Ann Machado - Re: 85 Avalon Rd. - Permit #2015-02392

From: Anthony Wilbur <awilbur27@gmail.com>
To: Ann Machado <AMACHADO@portlandmaine.gov>
Date: 10/9/2015 4:16 PM
Subject: Re: 85 Avalon Rd. - Permit #2015-02392
Attachments: 85AvalonModifiedPlans.pdf

I have started my review of the permit for zoning, but I cannot sign off yet because I need more information.

2A - Dimensioned Floor Plan

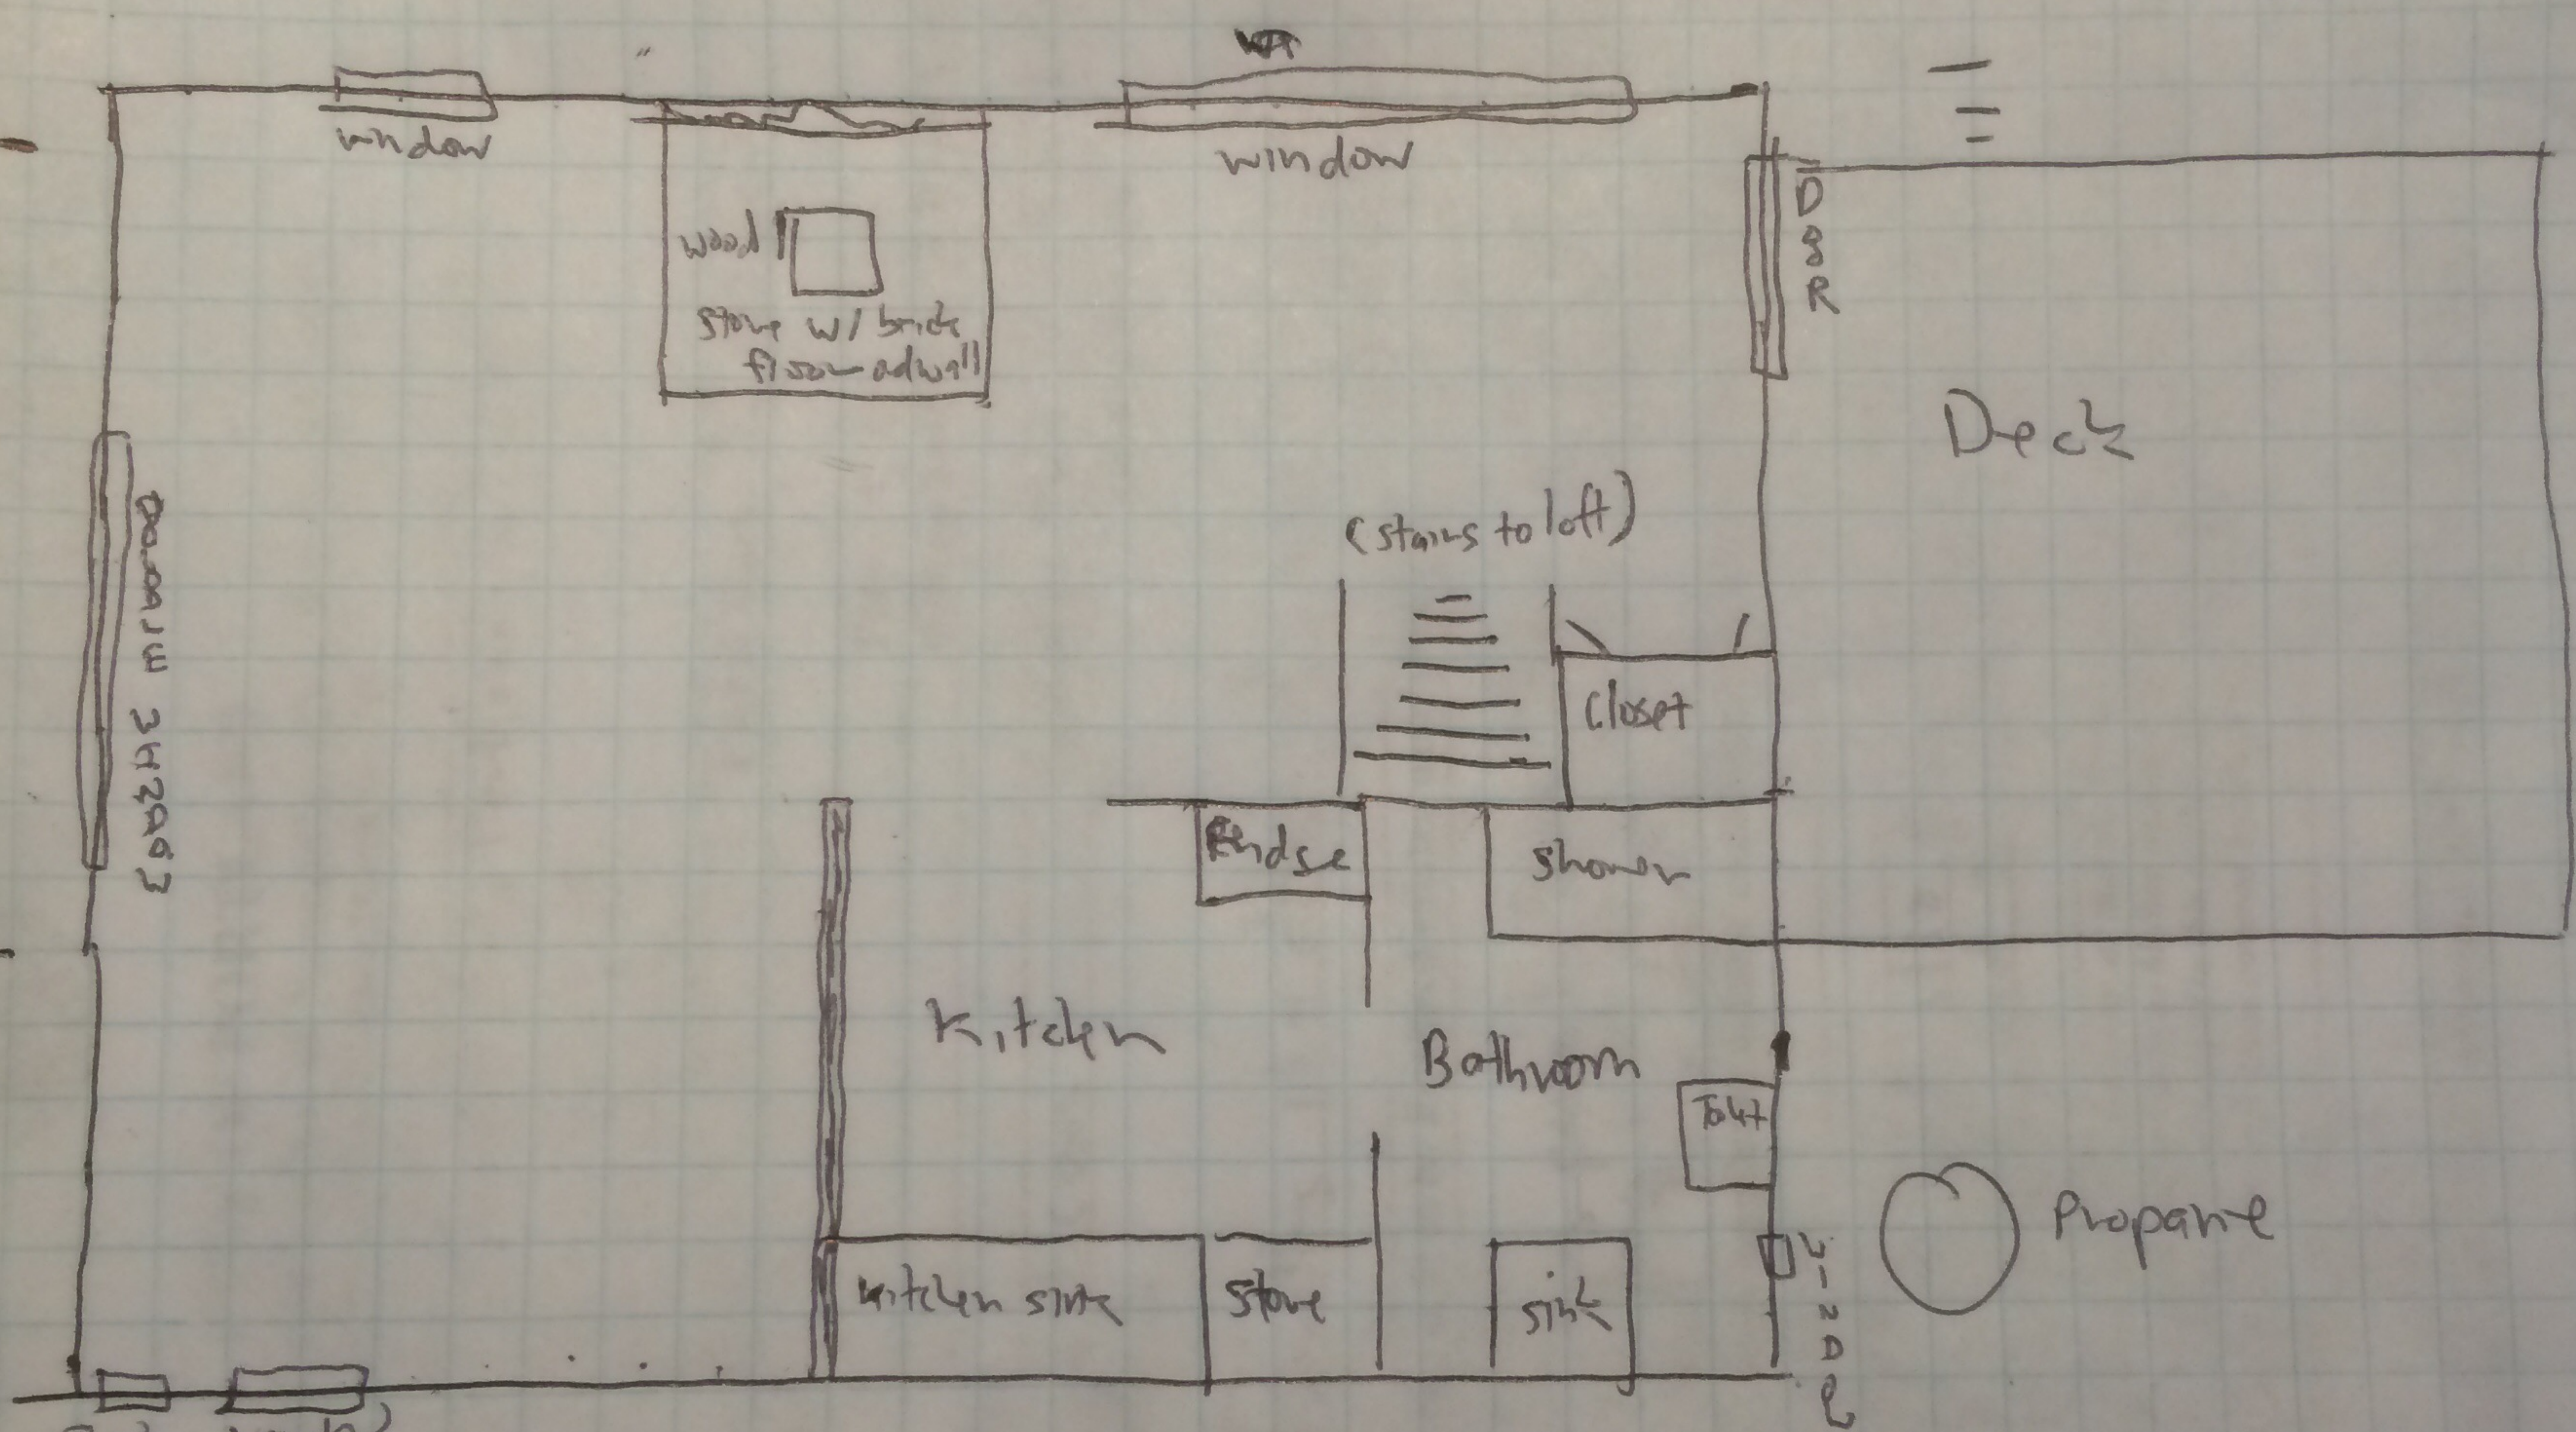
You also need to submit plans that show what is changing. You have submitted the existing floor plans but not how it is changing. For instance the proposed floor plan for the first floor needs to show the stairs being removed and the change to the bathroom that you are proposing. For the second floor you need to provide a proposed plan that shows how you are closing up the stairwell and calling the area storage, not bedrooms.

2B: Dimensioned Floor Plan

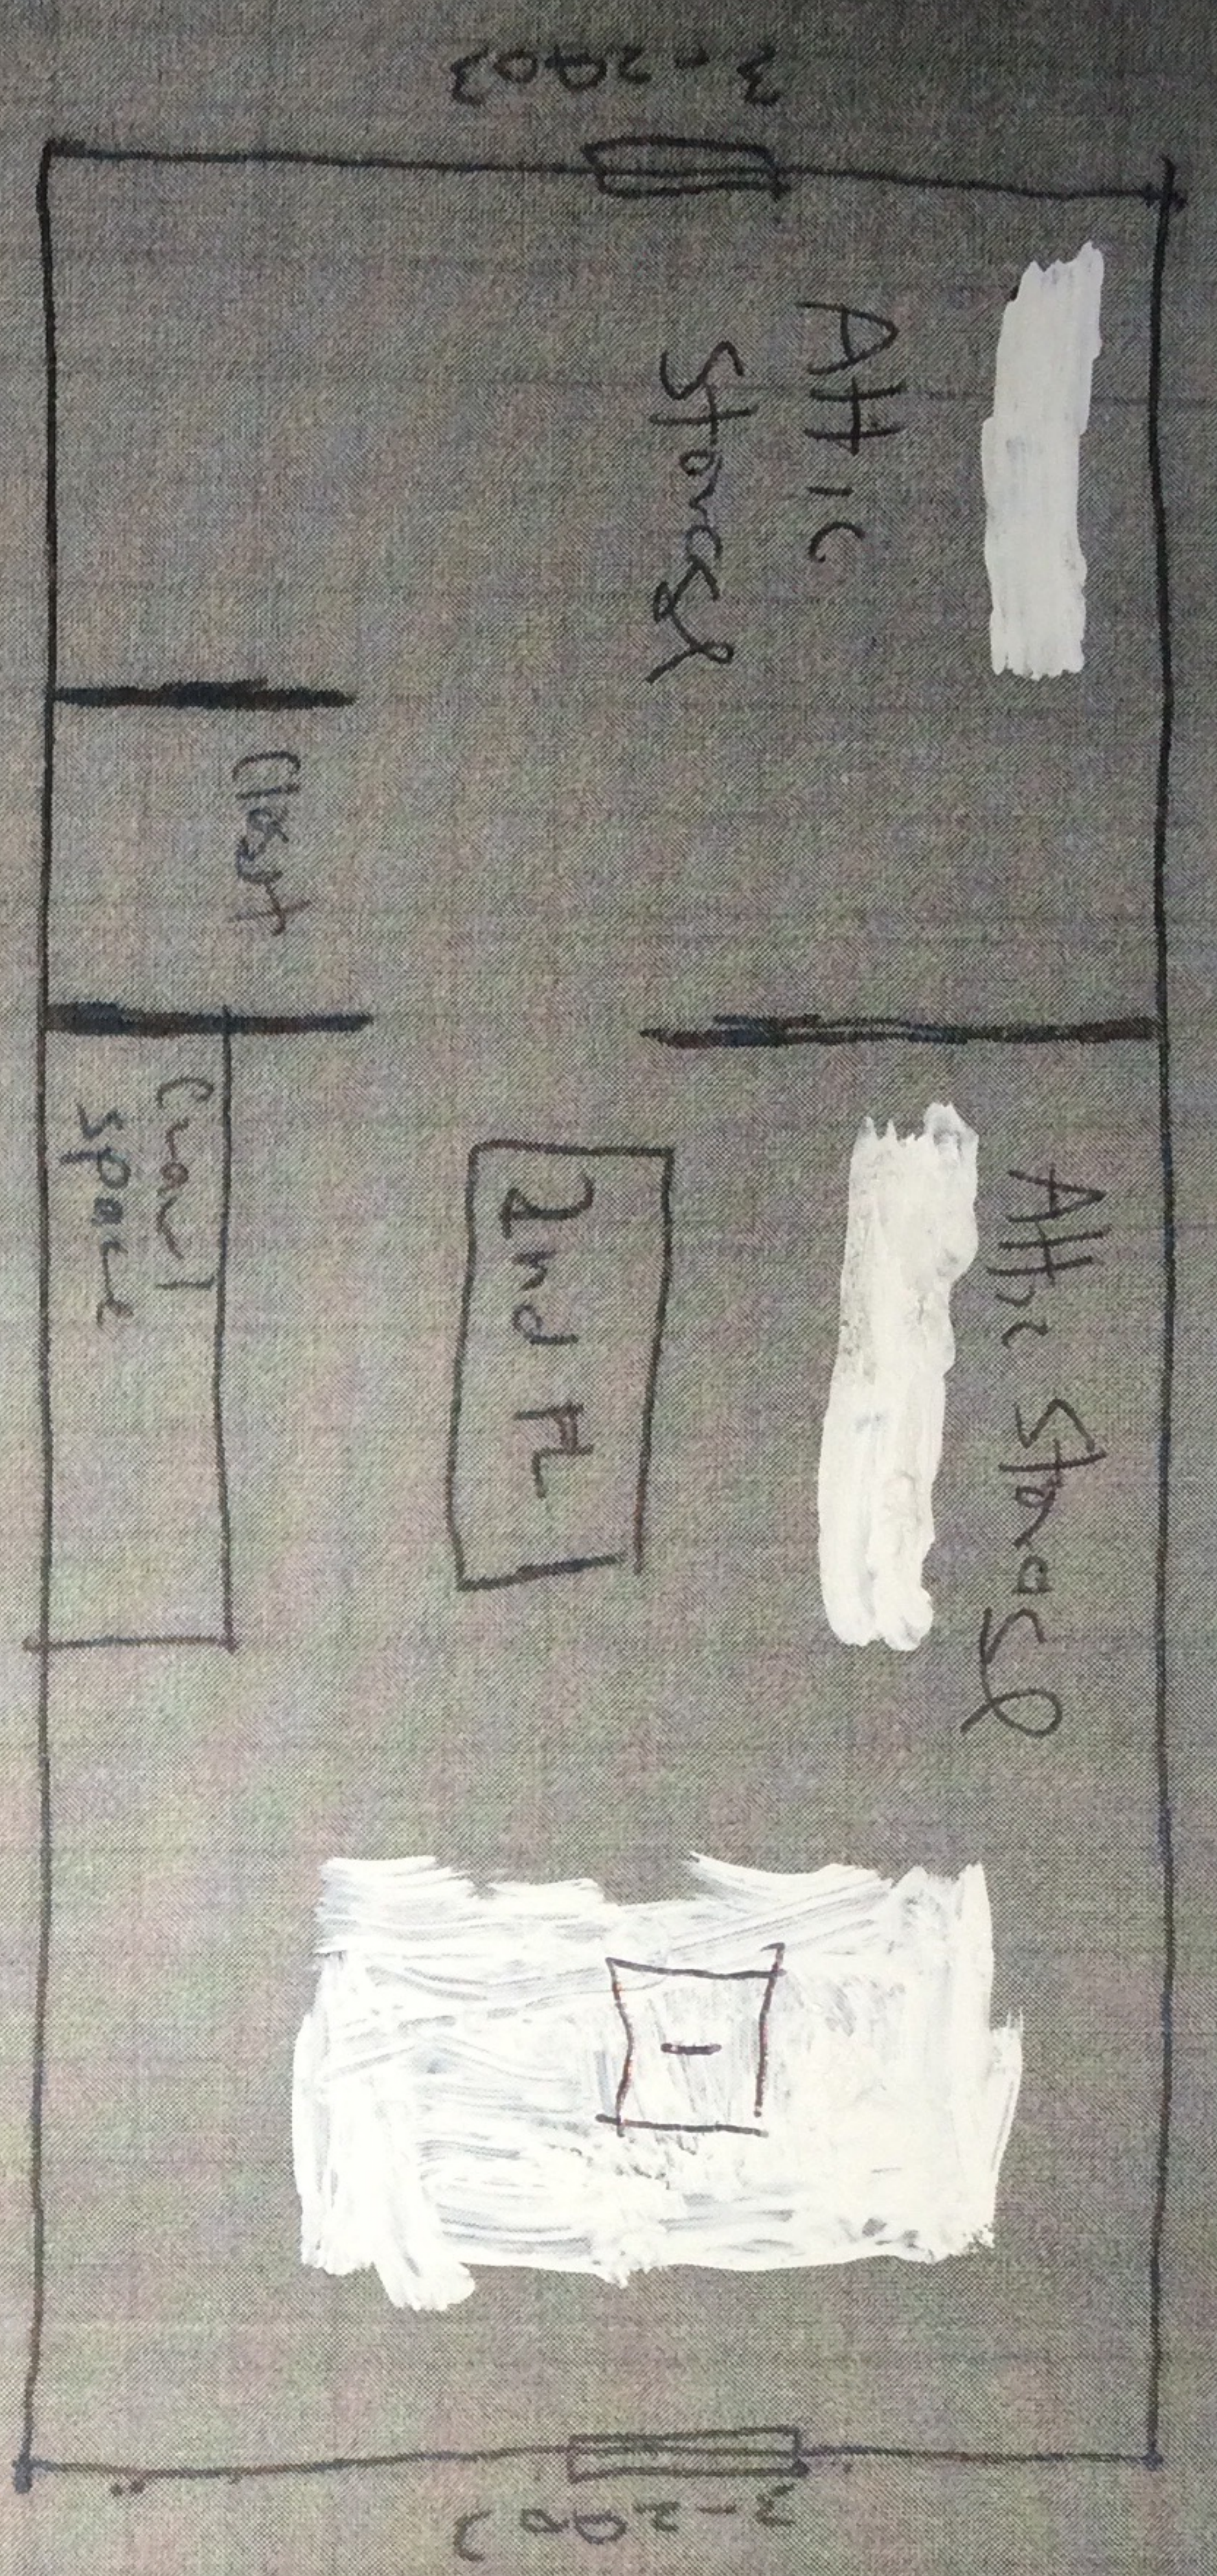
You also need to provide a framing plan for how you are closing up the old stairwell.

I have taken the original floor plans and modified them to show the intended changes that you require. The new scan is a poorer quality than the original but hopefully you can make it all out. I also provided a picture of the drop-down attic ladder that I will most likely install once the current stairs are removed. The image shows how I intend to install the stairs as well. The stairs that are currently in now (to be removed) are only attached by one large hinge, so it's not a huge construction project. I have also been debating simply putting a simple trap door in (noted on the floor plans), but I will most likely put the pull down ladder in.
